# CITY OF ALBUQUERQUE

**Re: Unser Crossing- Building A**  
**10550 Unser Blvd NW**  
**Request for Certificate of Occupancy-30 Day Temp**  
**Transportation Development Final Inspection**  
Architect's Stamp date 7-20-21 (A11D017B)  
Certification dated 2-27-24

SHEET NUMBER
AS-1.1

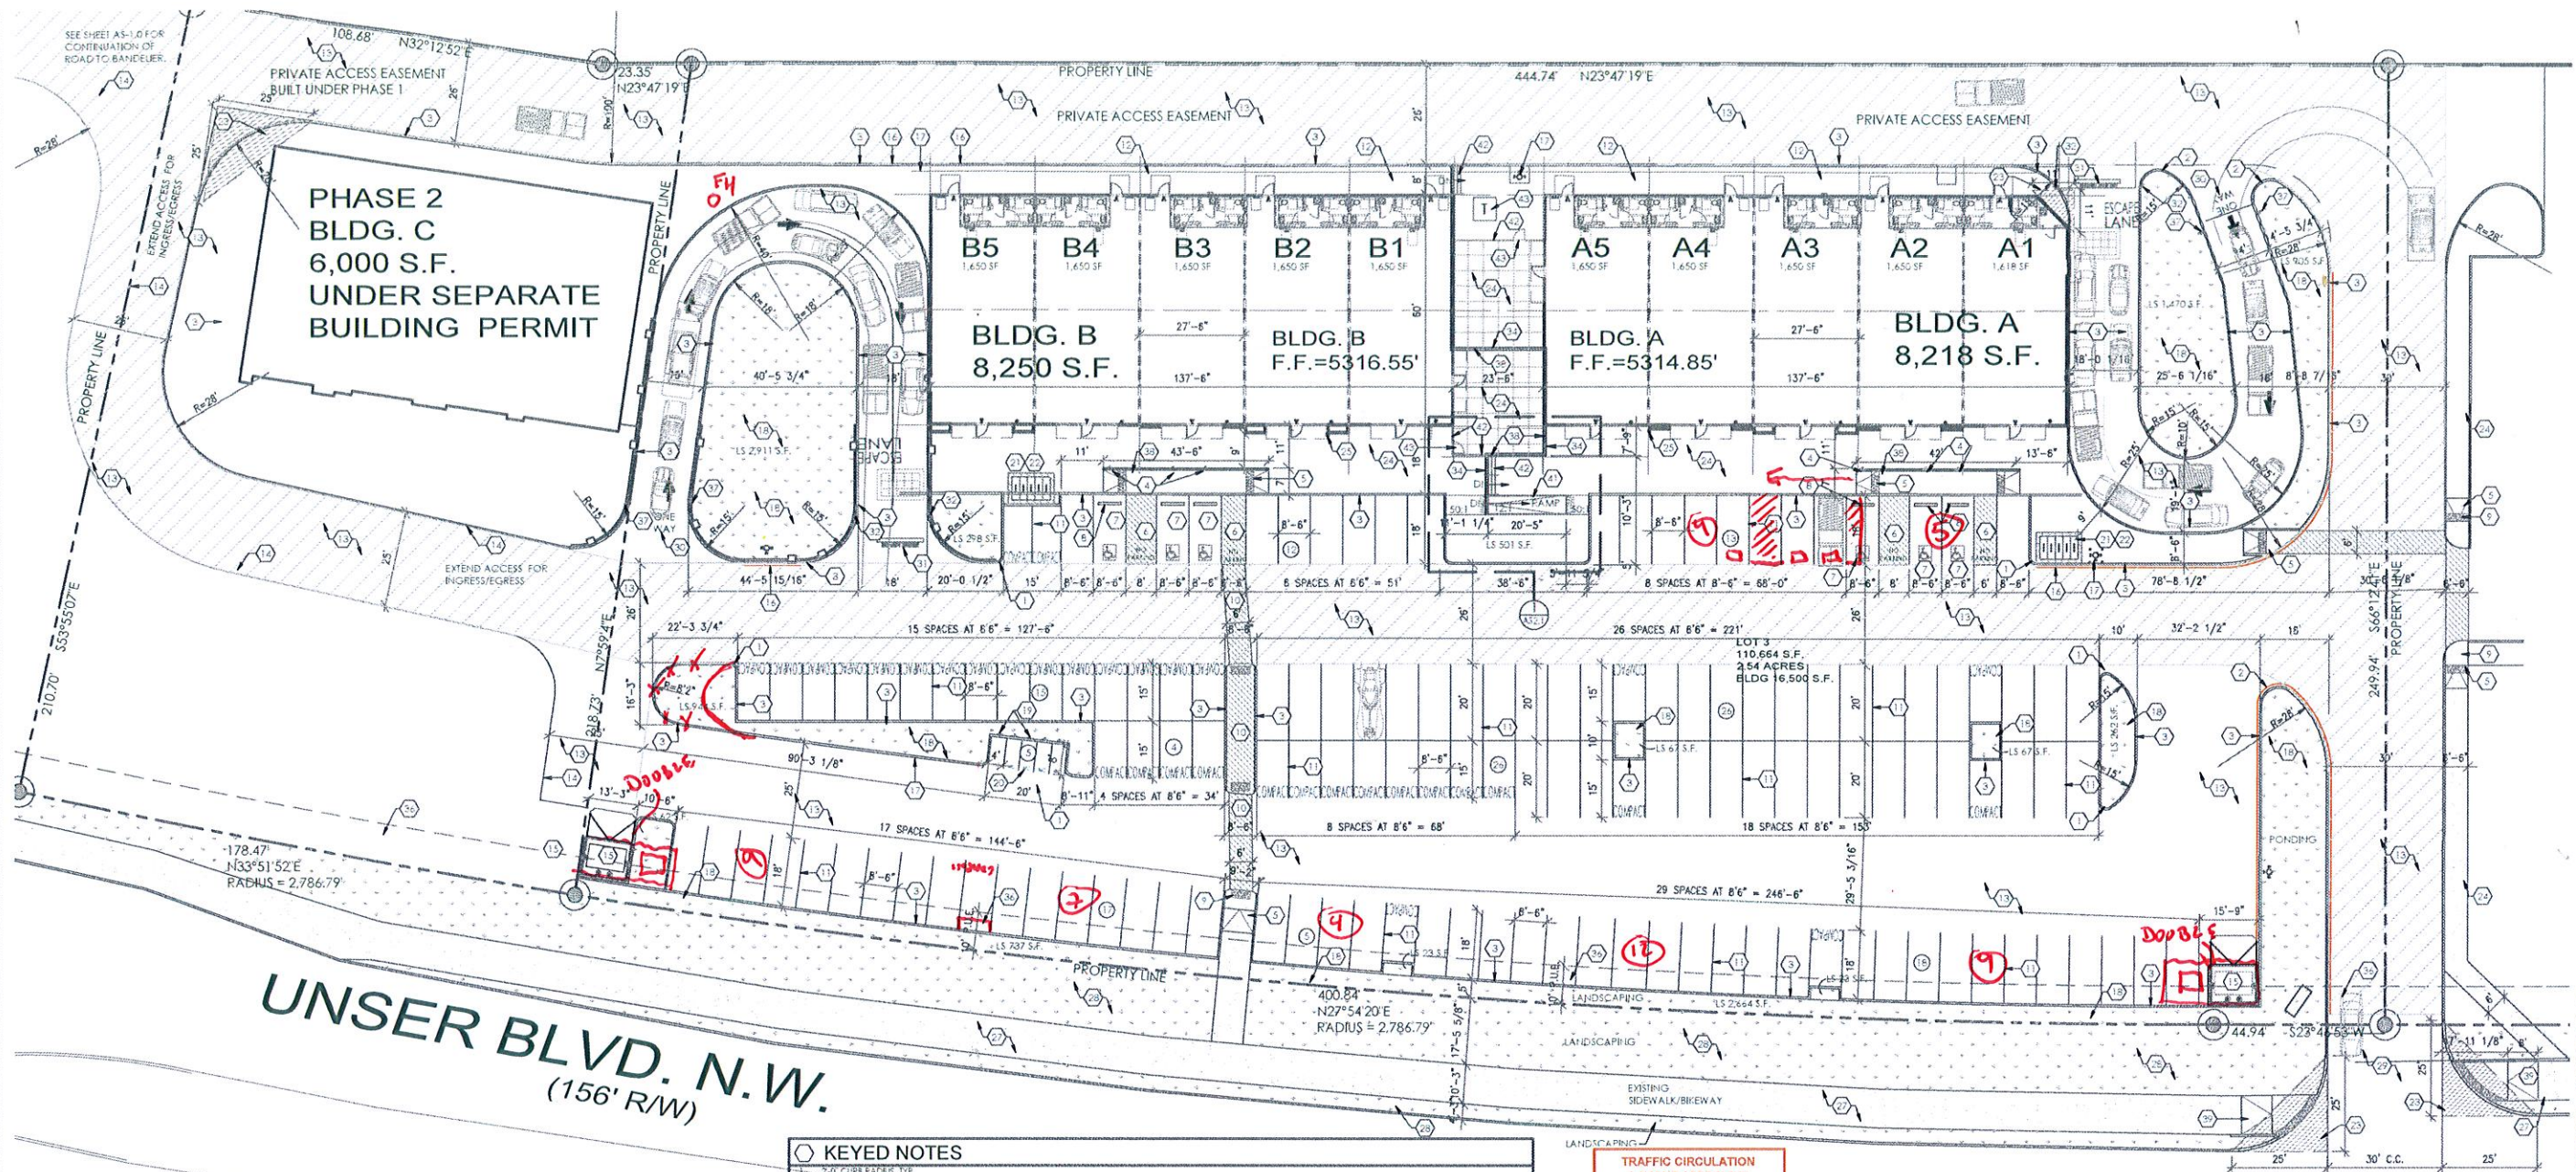
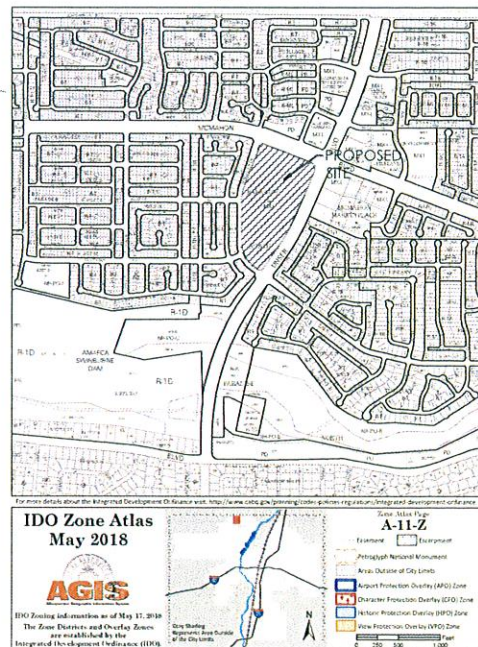
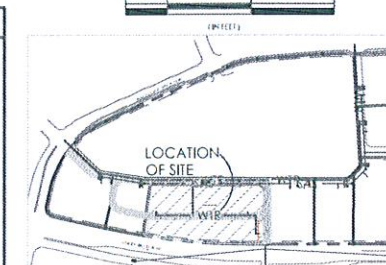
1. The installed size of each bike rack was not per plan: 14" wide.
2. The installed spacing between bike was not spaced per plan: 16" apart.
